Recommendation Report for Planning Permission for Works or Extension to a Dwelling

REF NO: FP/43/21/HH

LOCATION: 14 Felpham Way
Felpham
PO22 8QT

PROPOSAL: Side and rear extension.

Proposed Side & Rear Extension		
Plans and Elevations		
Planning		
Date		
March 2021		
Scale		
1:50

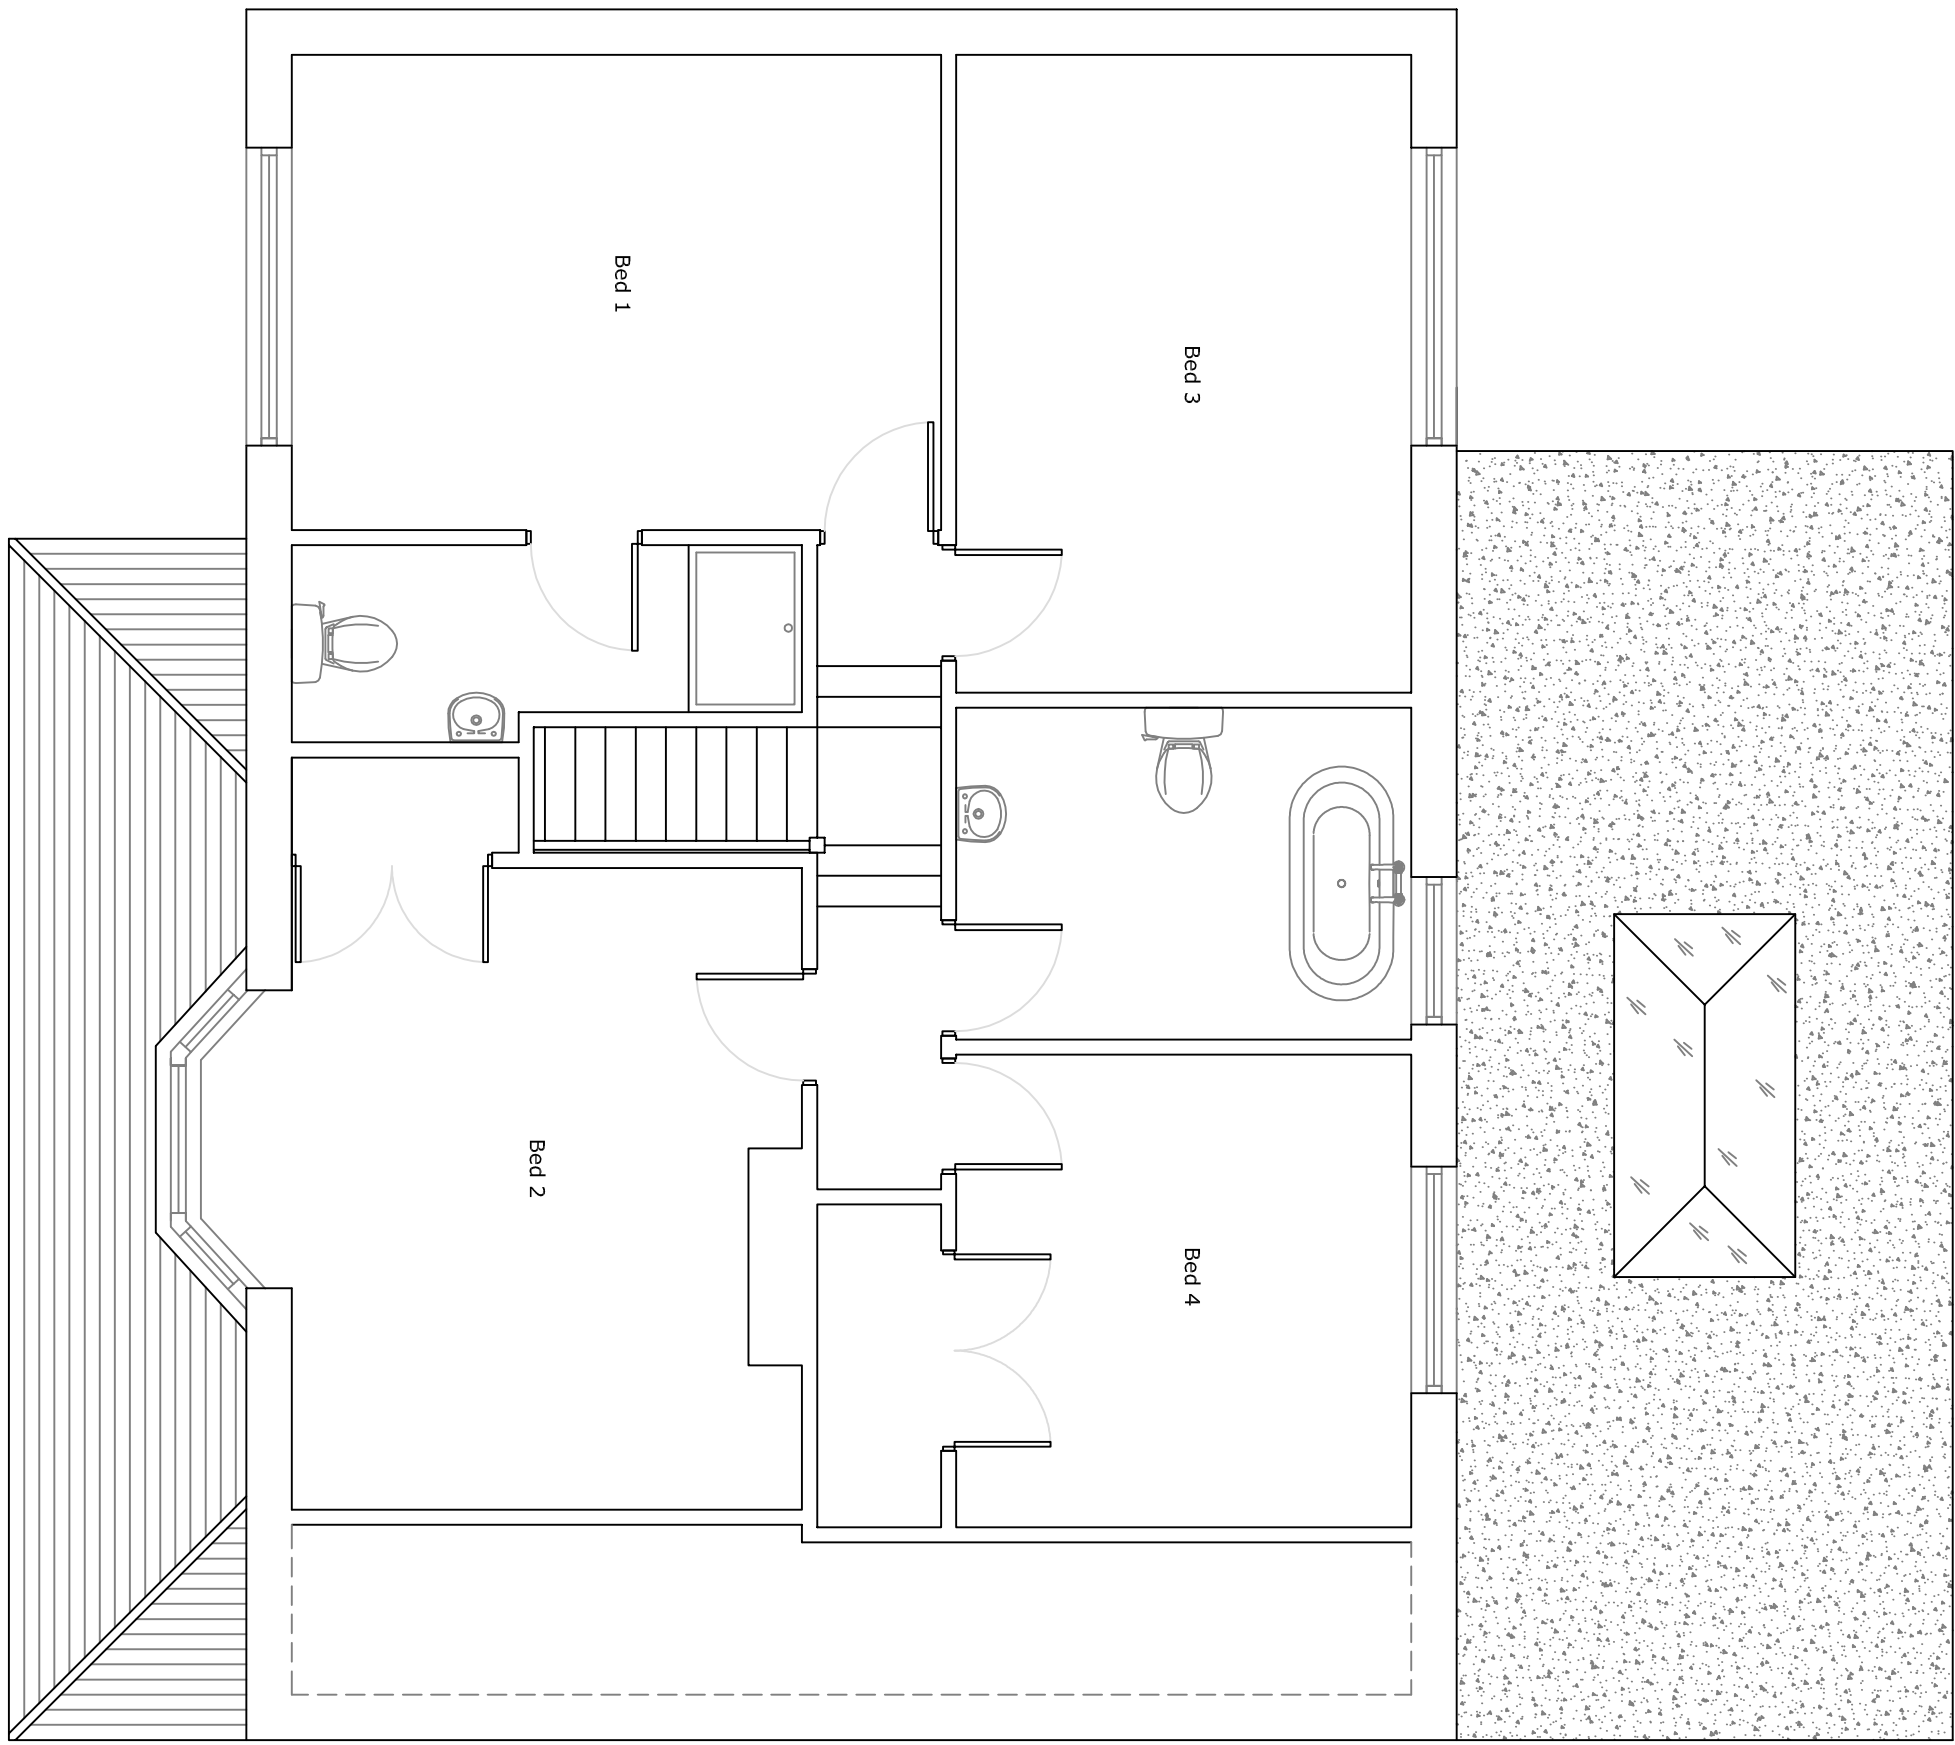
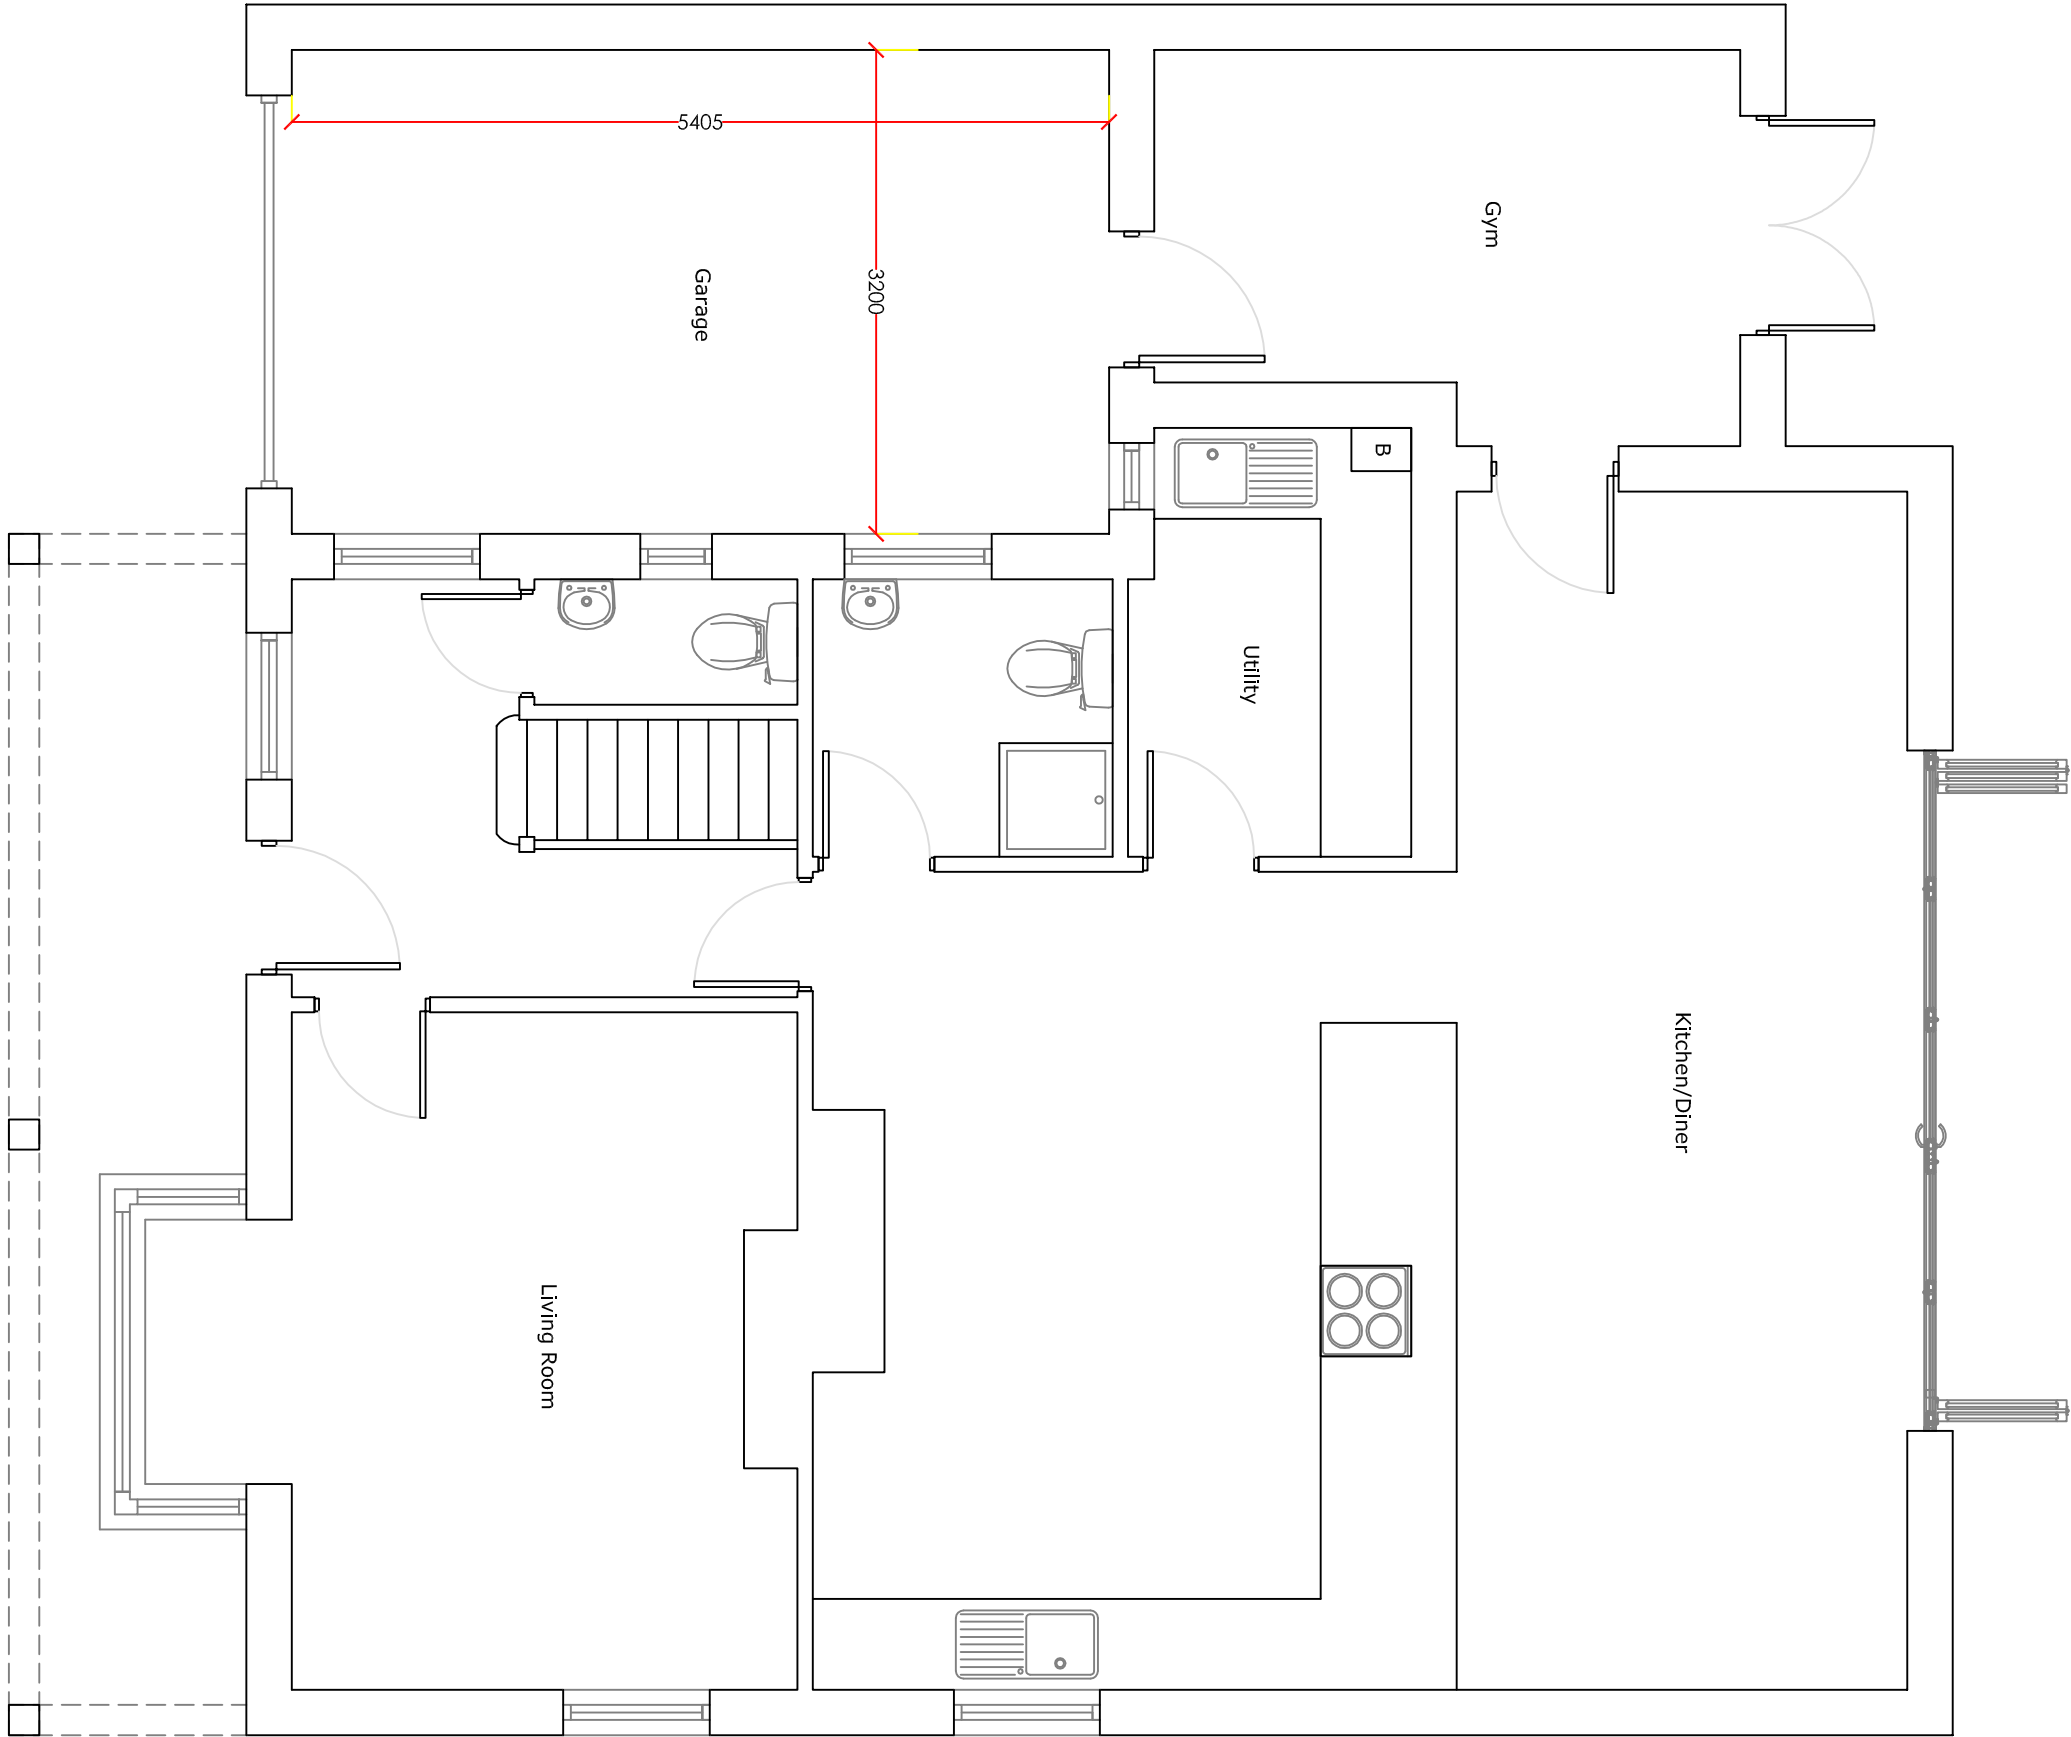
The proposal is to have a garage on the ground floor which in addition to the space in front of it will provide for 2 spaces involving the loss of 1 space from the existing. This is considered to be acceptable

although it will not meet the guidelines from the Arun Parking Standards SPG which require 3 spaces for a 4 bed dwelling
